Appeal Decision

Appeal Ref: APP/T2350/D/21/3280453

The Glebe Barn, Main Street, Gisburn BB7 4HR

- The appeal is made under section 78 of the Town and Country Planning Act 1990 against a refusal to grant planning permission.
 - The appeal is made by Mr Andrew Weir against the decision of the Ribble Valley Borough Council.
 - The application Ref 3/2021/0469 dated 29/04/2021, was refused by notice dated 23/07/2021.
 - The development proposed is described as detached garage/store on land to the west of Glebe Barn.
-

name
proposed plan and elevations

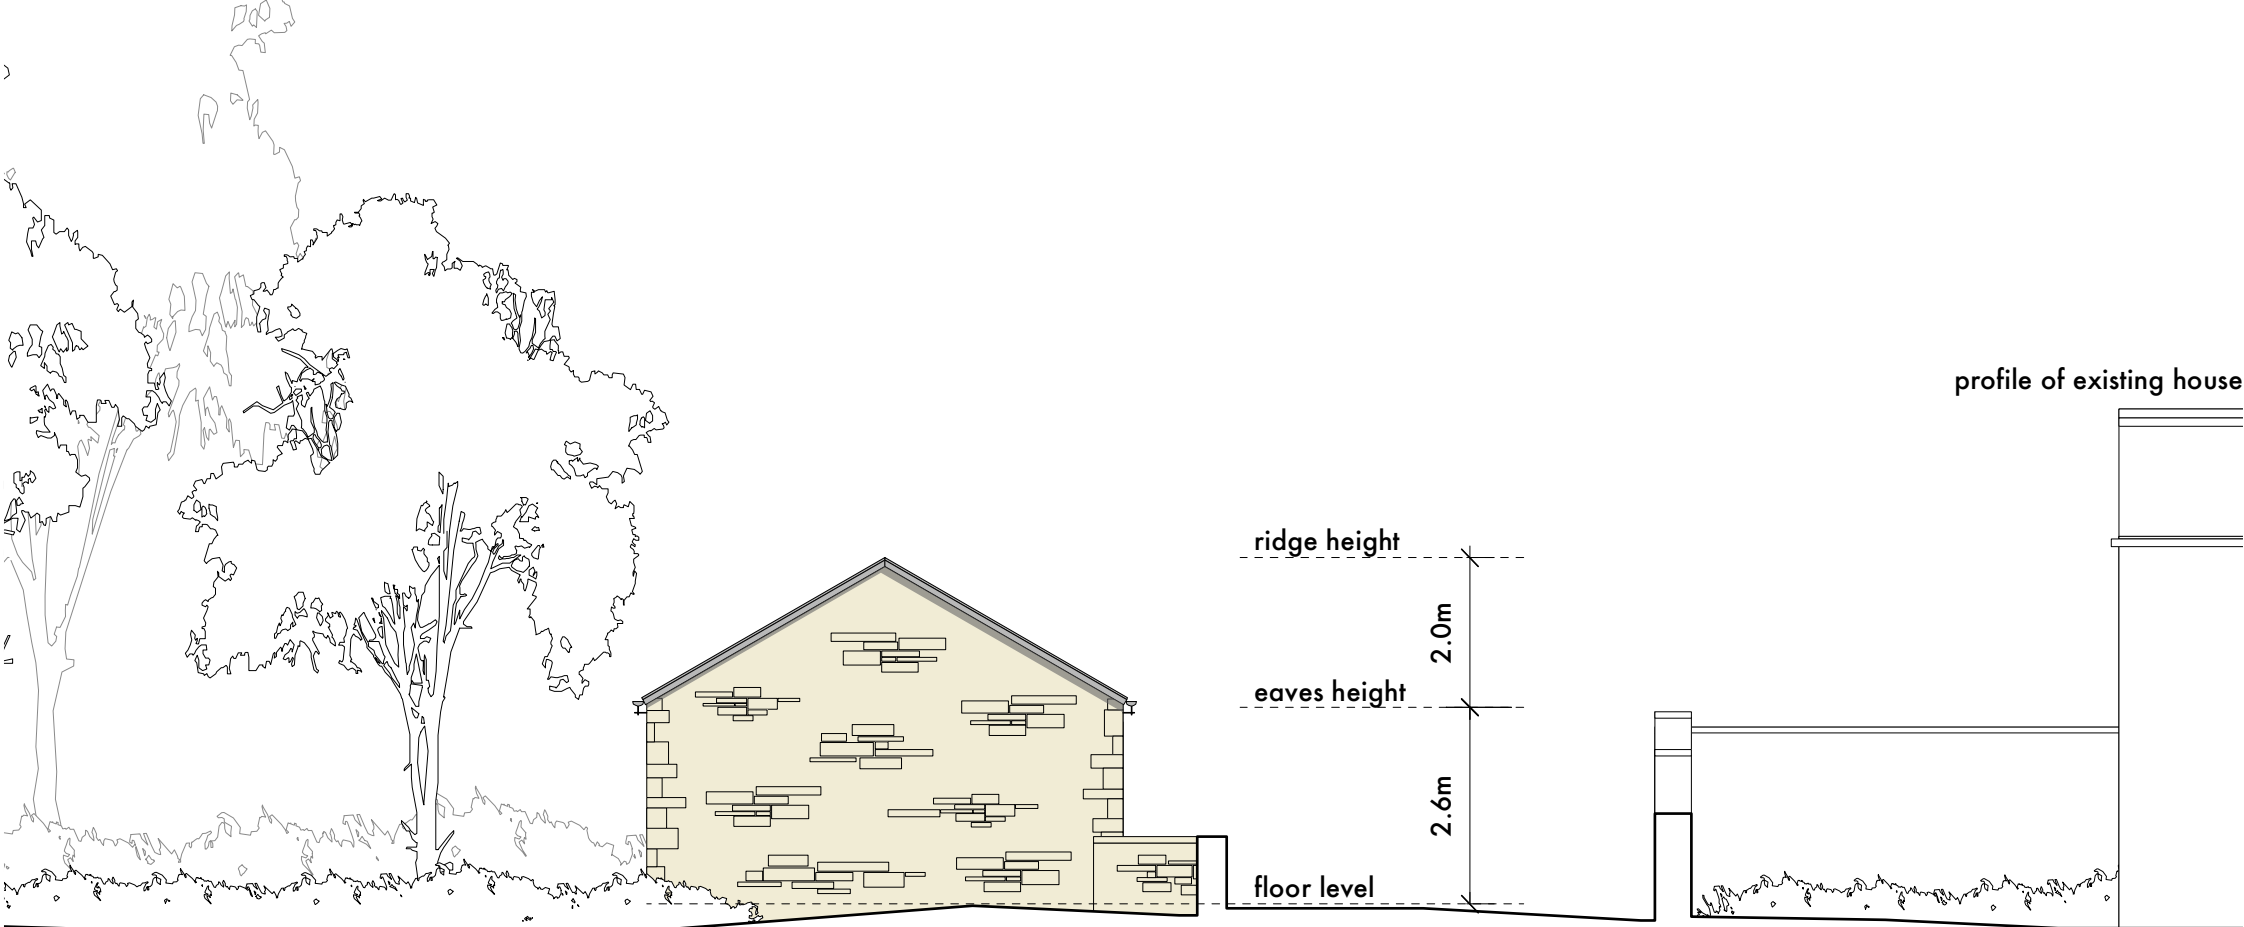
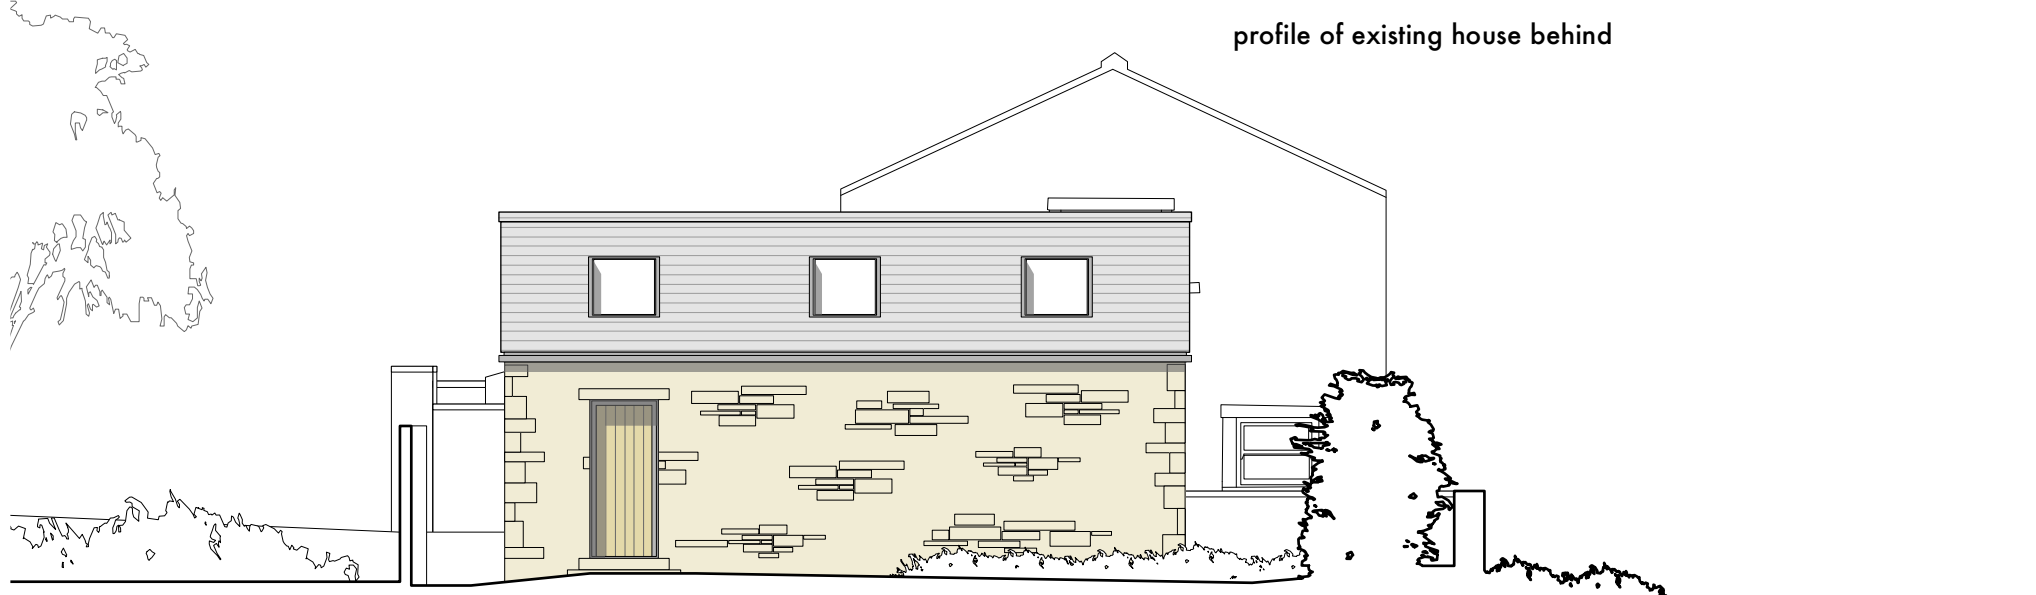
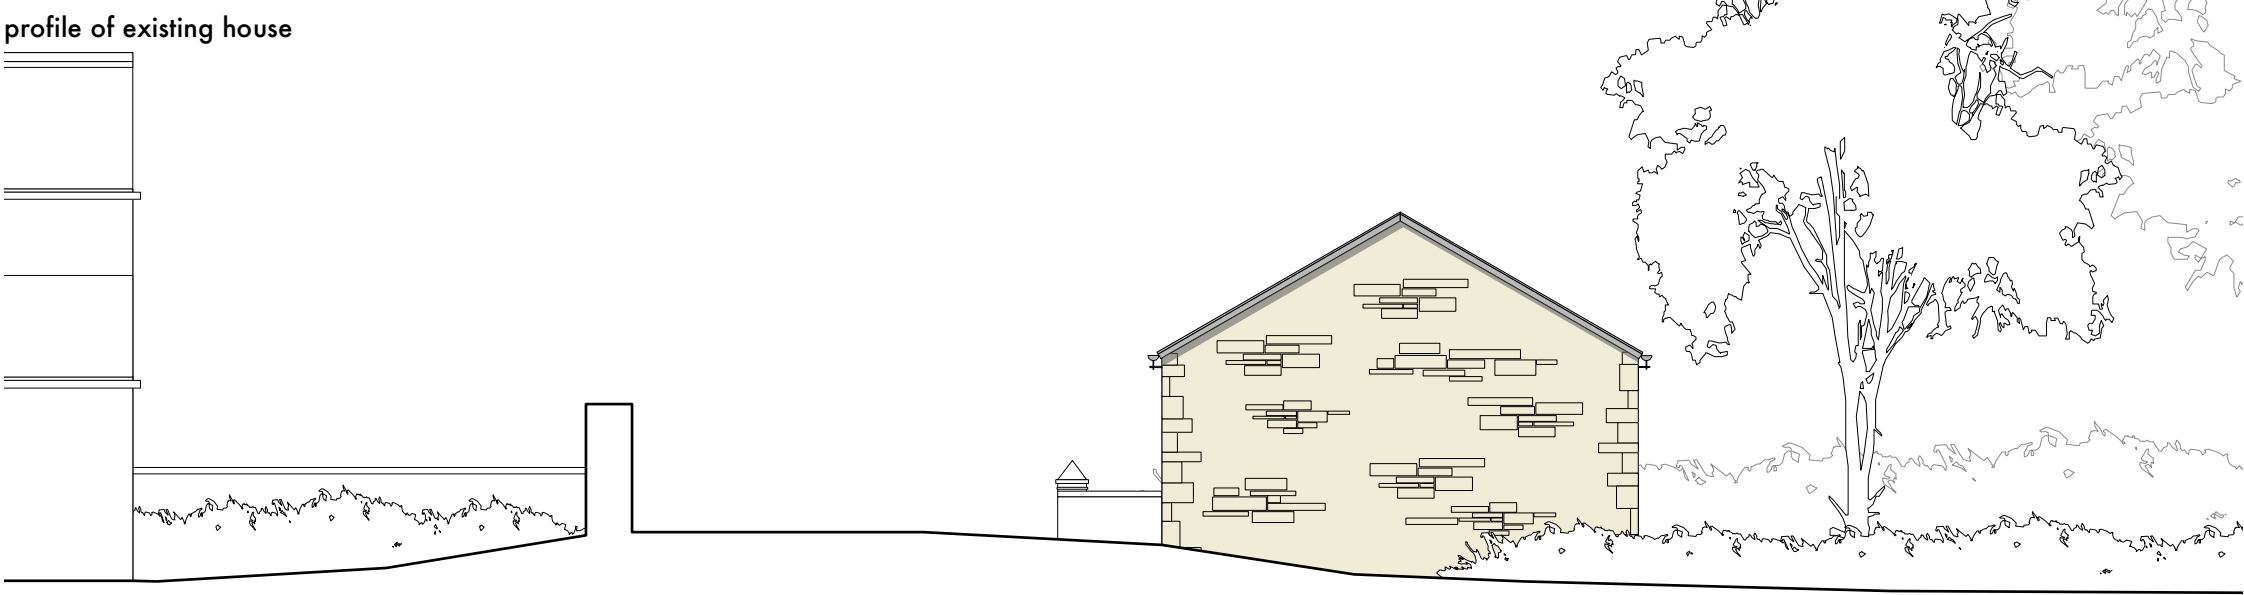
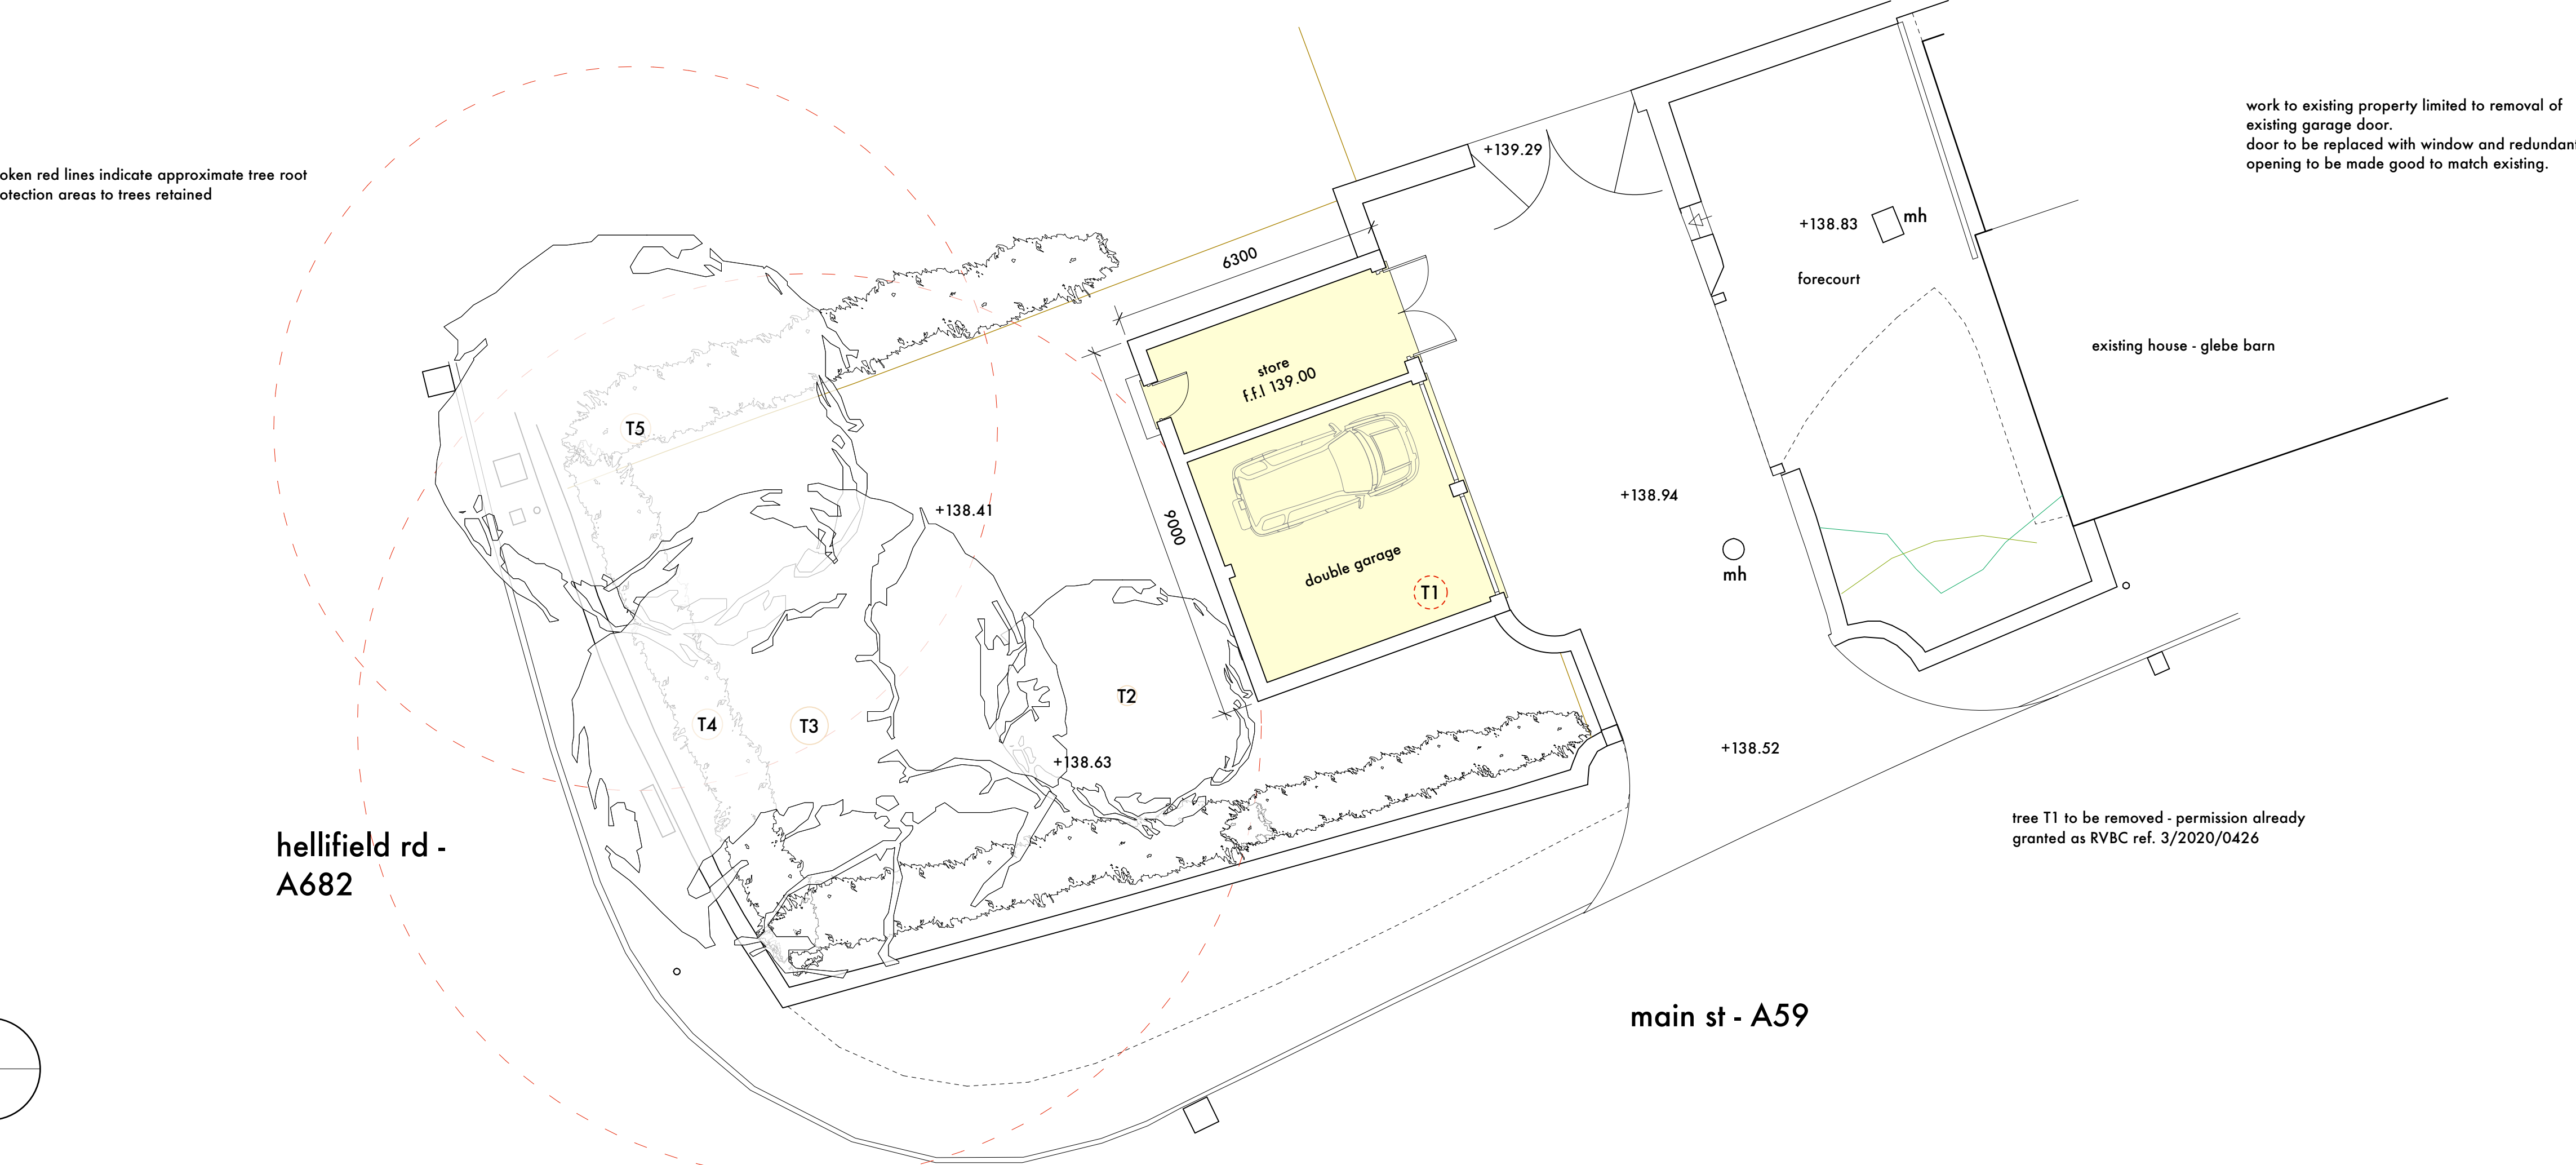
11. Notwithstanding this the proposed development includes rooflights to the rear roof slope. The existing trees would screen the rooflights to some degree, however they would be visible from an important view identified on the Townscape Appraisal Map from Park View east towards the site. Whilst I noted during my site visit that there are rooflights in other properties within the immediate area, the low level of the proposed rooflights would be an incongruous feature to the streetscene which would not preserve nor enhance the conservation area.
